Application no: 24/03259/F

Location: Land Adjacent to Symmetry Park, Morrell Way, Bicester, OX26 6GF

Lead Local Flood Authority

Objection

TITLE		
CATCHMENT PLAN		
HYDROCK PROJECT NO. 22281	SCALE @ A1 1:1000	
STATUS DESCRIPTION SUITABLE FOR REVIEW & COMMENT		STATUS S3
DRAWING NO. 22281-HYD-XX-XX-DR-C-0530		REVISION P02

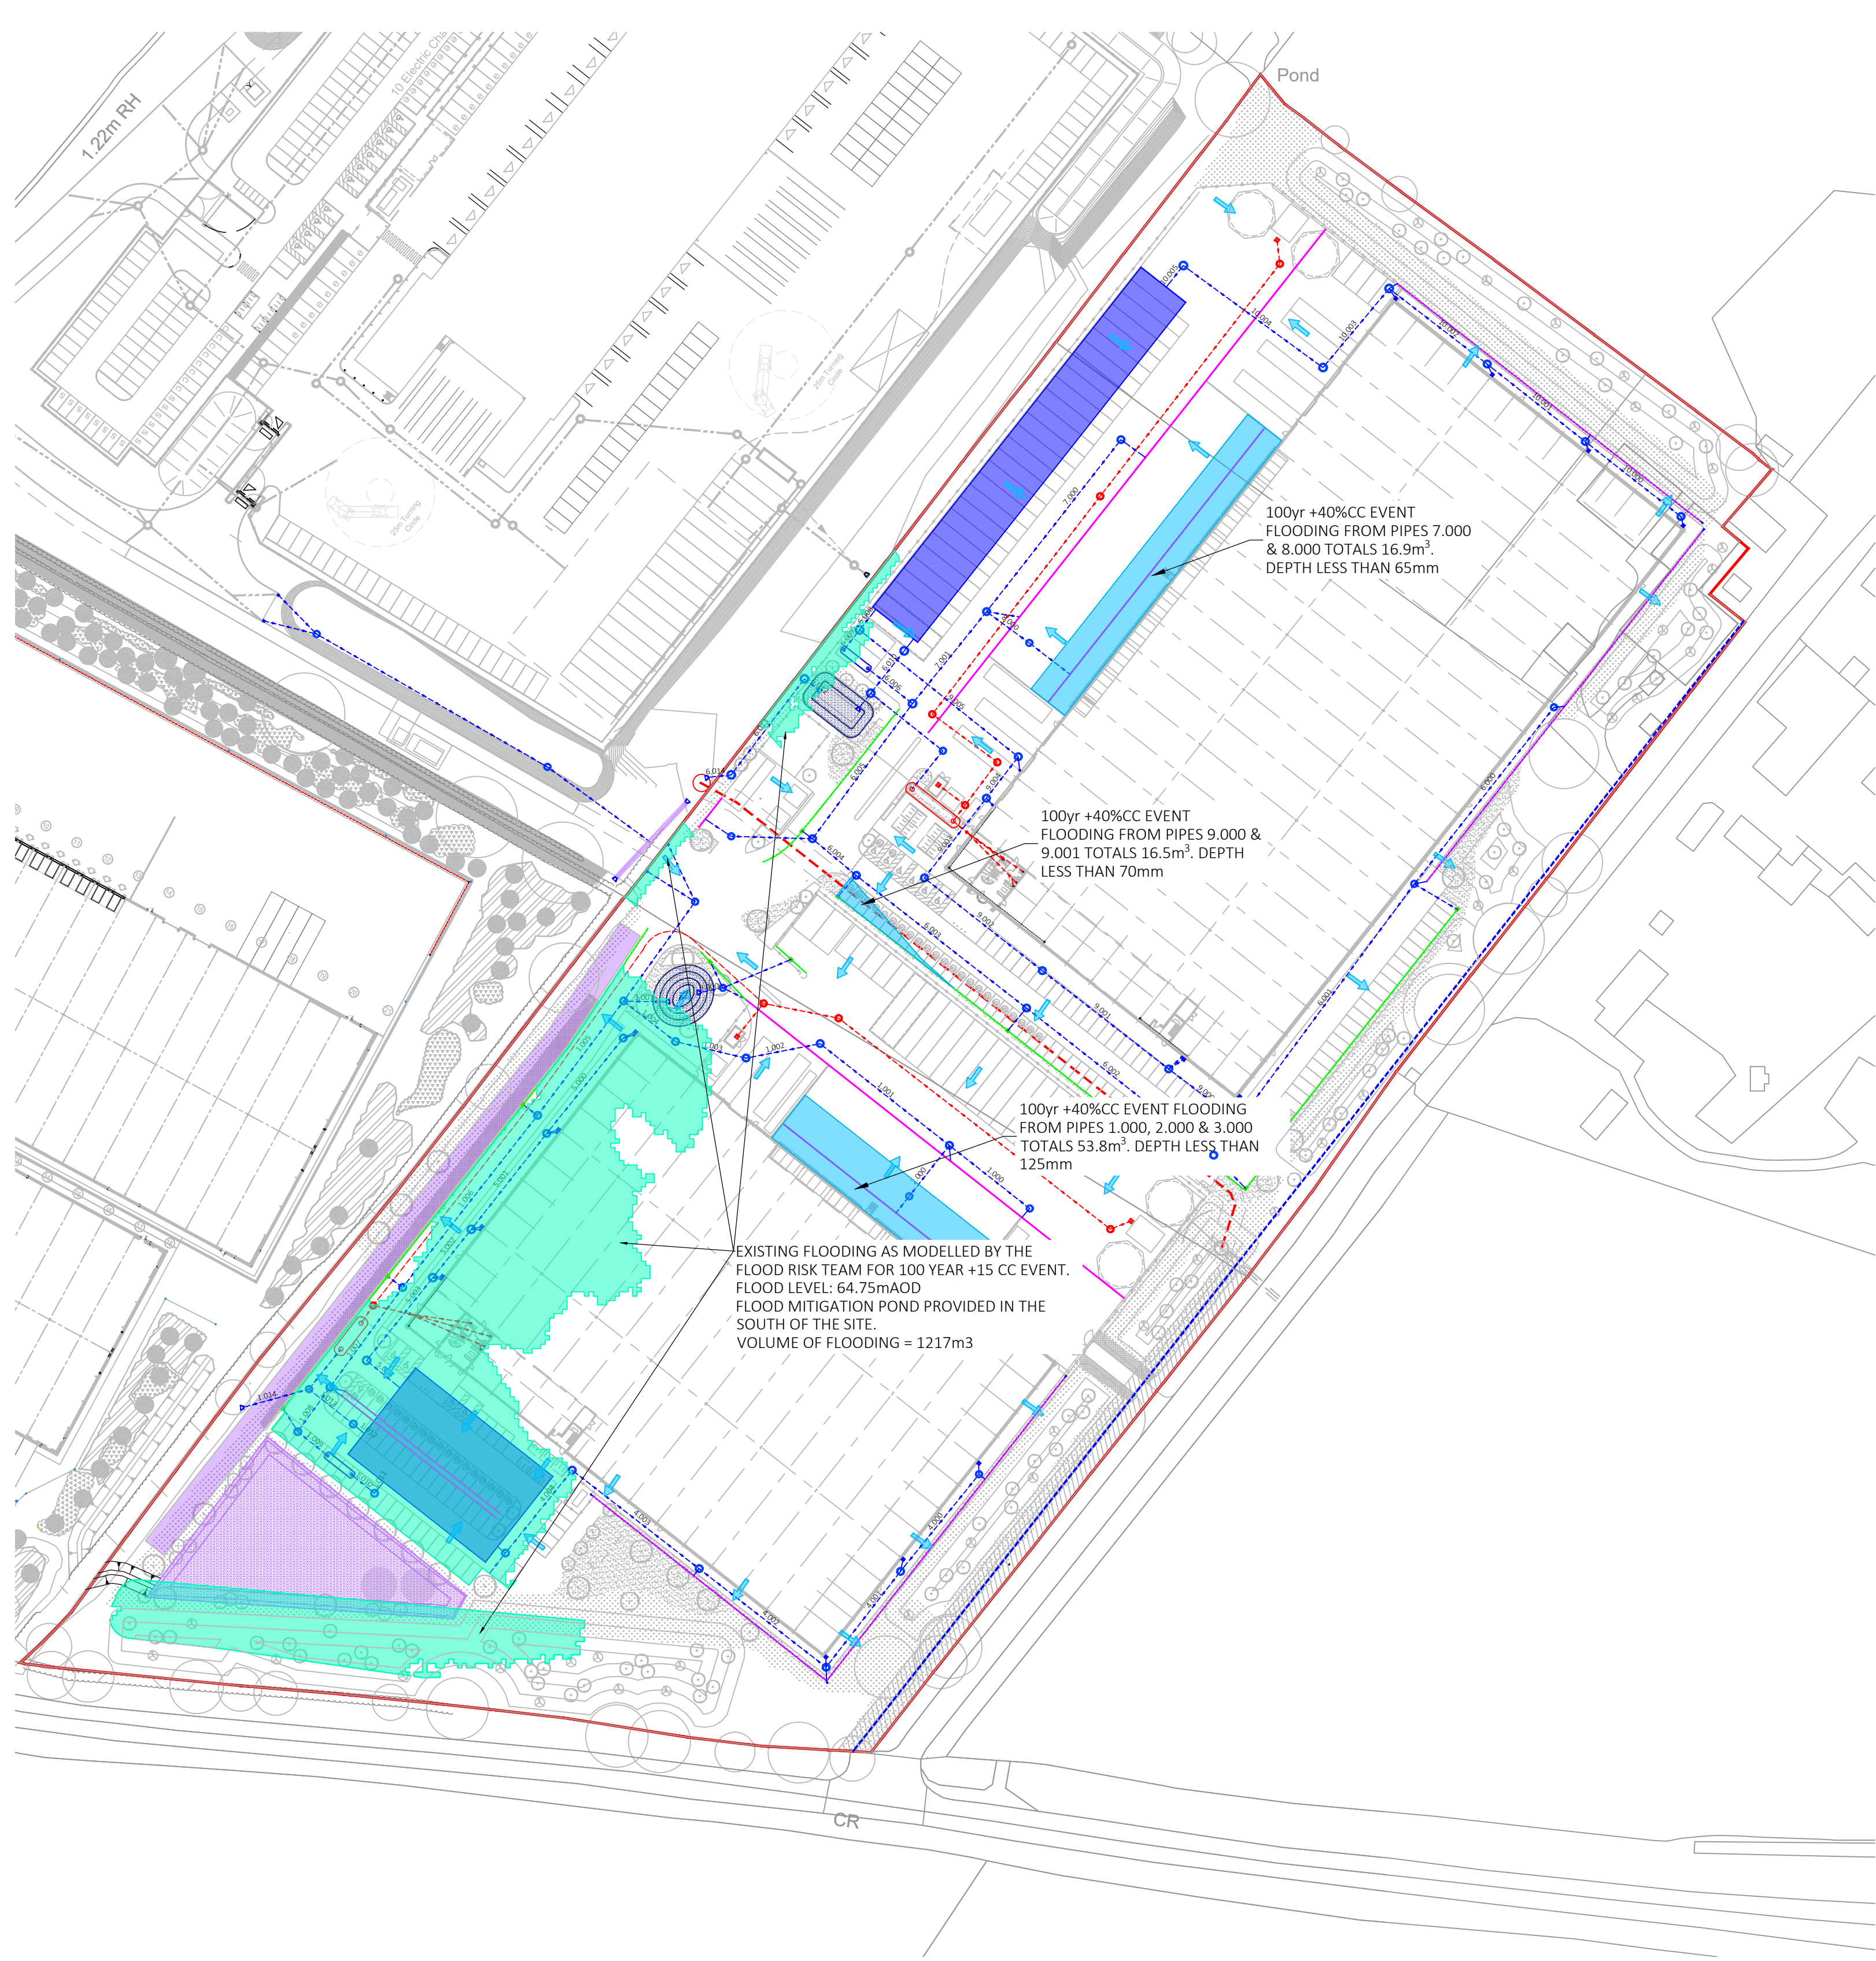
Provide surface water catchment plan, clearly showing the extent of the impermeable area and stating the area. Each catchment should show where it will be draining.

Proposed Calculations to read in line with the catchment plan produced, clearly referencing pipe numbers and SuDS. Calculations to be provided for all storm events up to and including the 1:100 year plus 40% climate change.

TITLE FLOOD EXCEEDANCE PLAN		
HYDROCK PROJECT NO. 22281	SCALE @ A1 1:1000	
STATUS DESCRIPTION SUITABLE FOR REVIEW & COMMENT		STATUS S3
DRAWING NO. 22281-HYD-XX-XX-DR-C-0540		REVISION P02

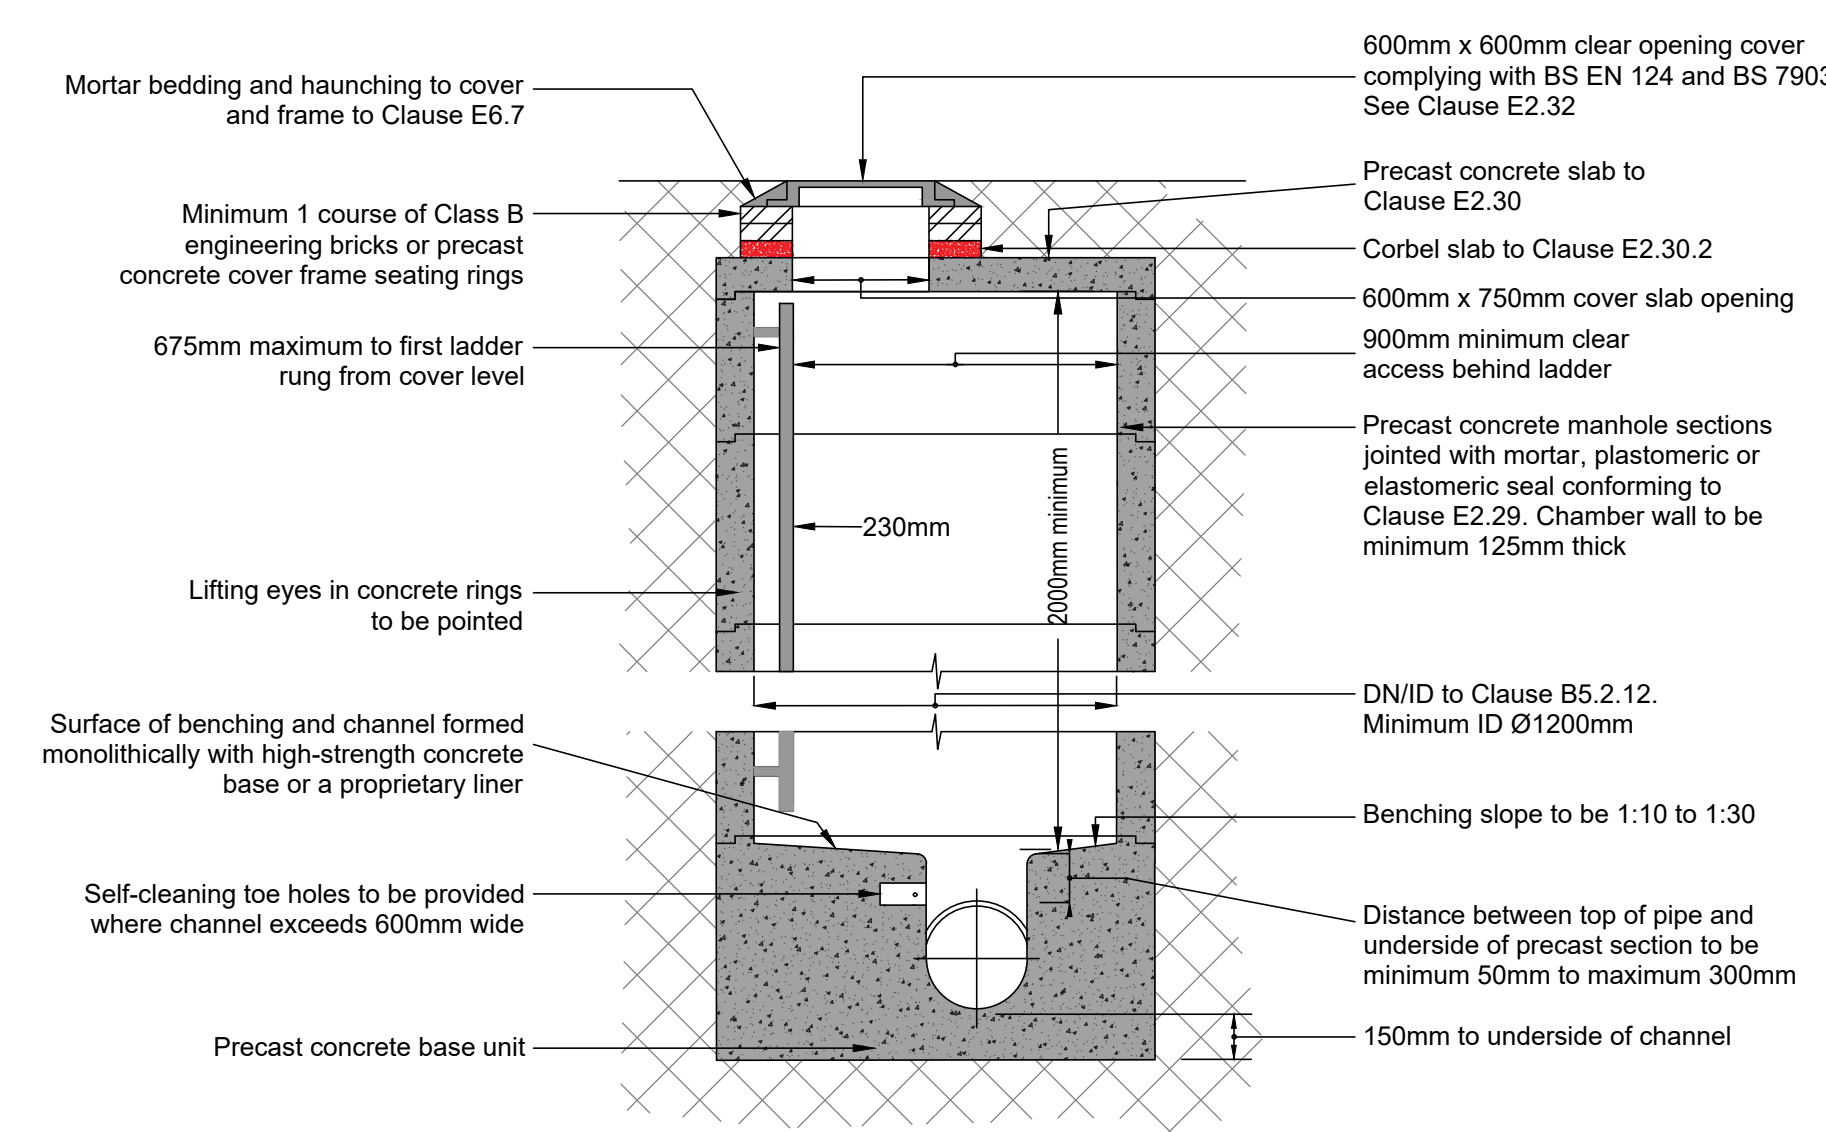
Provide flood exceedance plan, showing how surface water will be draining with the use of flood arrows.
